## Application for a Non-Material Amendment Following a Grant of Planning Permission

1) On the front elevation. Change the lower part of the front facade to be rendered, instead of brick. The note currently states 'brick to match existing'

2) At the rear of the house, to change the material used in the construction of the projecting bay/box window on the Family Room. The drawing note specifies 'insulated Aluminium cheeks'.

Proposed layout

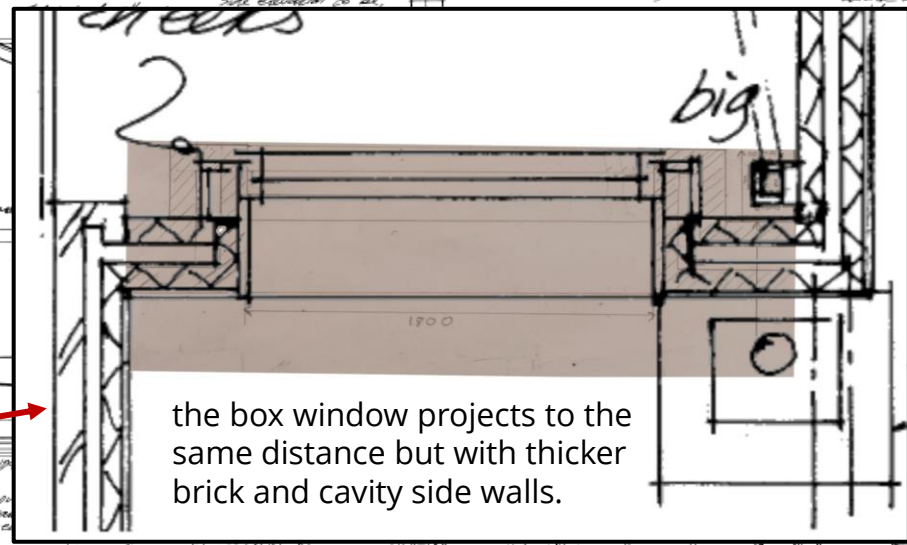
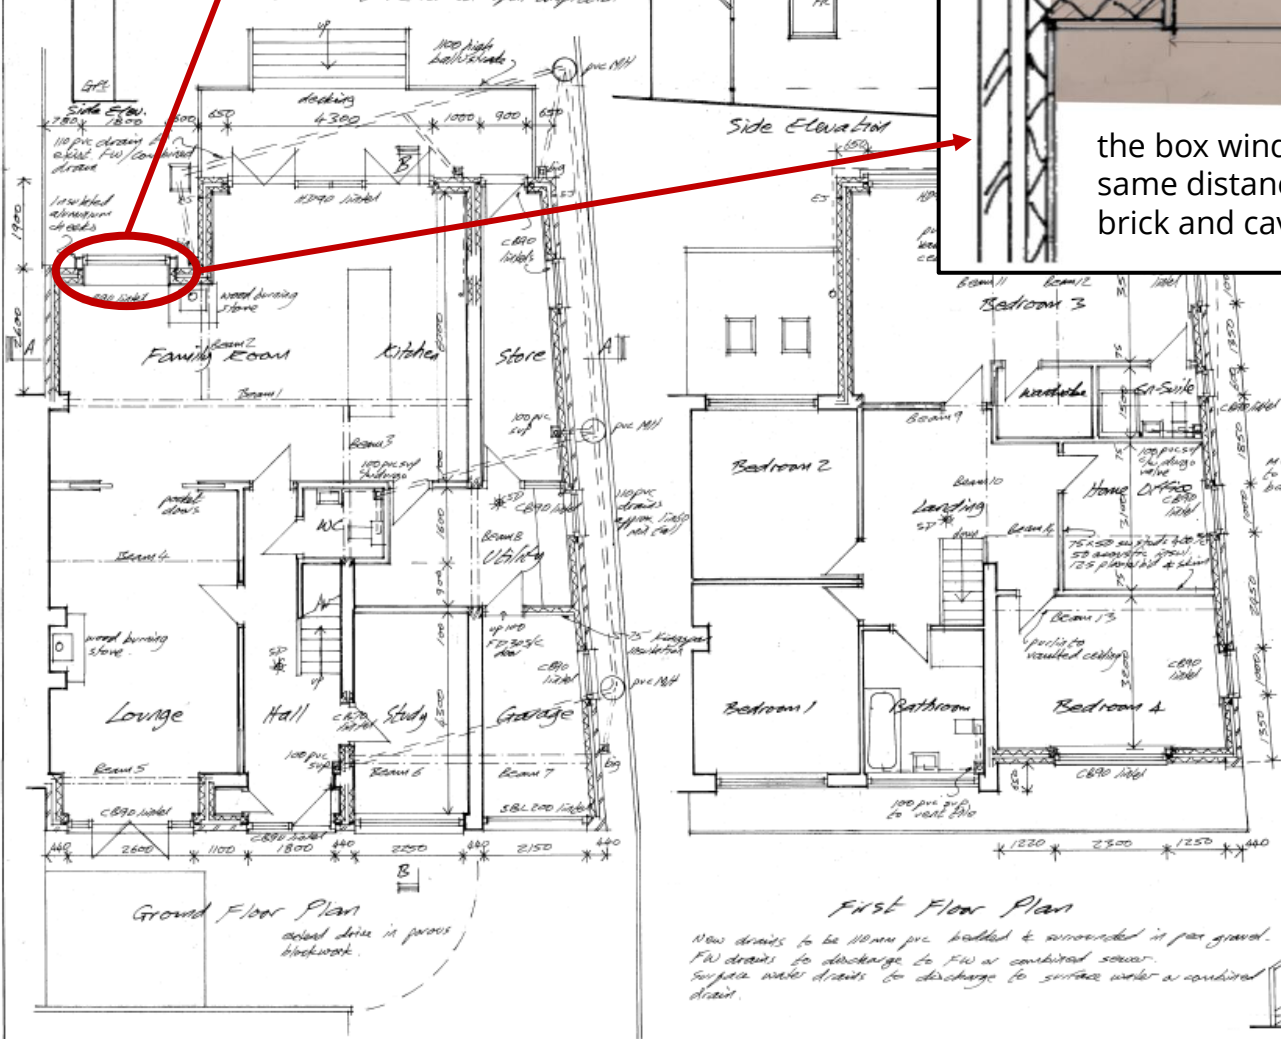
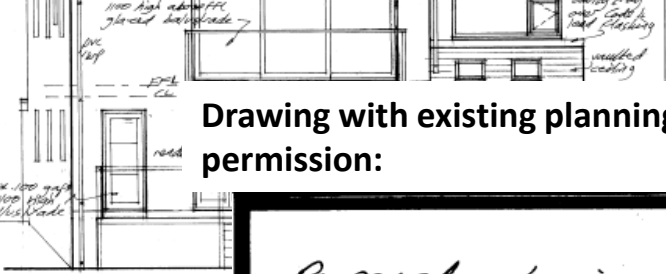
Proposed change is to use brick for the window side walls, and support the projection on masonry, rather than as an unsupported projection. The window remains the same, with no change to size or position.

2) An aluminium frame is worse for allowing heat to escape than a cavity wall brick design. The design previously granted permission will be more costly to build, more costly to heat and result in larger CO2 emissions from the extra heating needed, since it will lose more heat due to transfer through the aluminium walls, floor and roof than the proposed design.
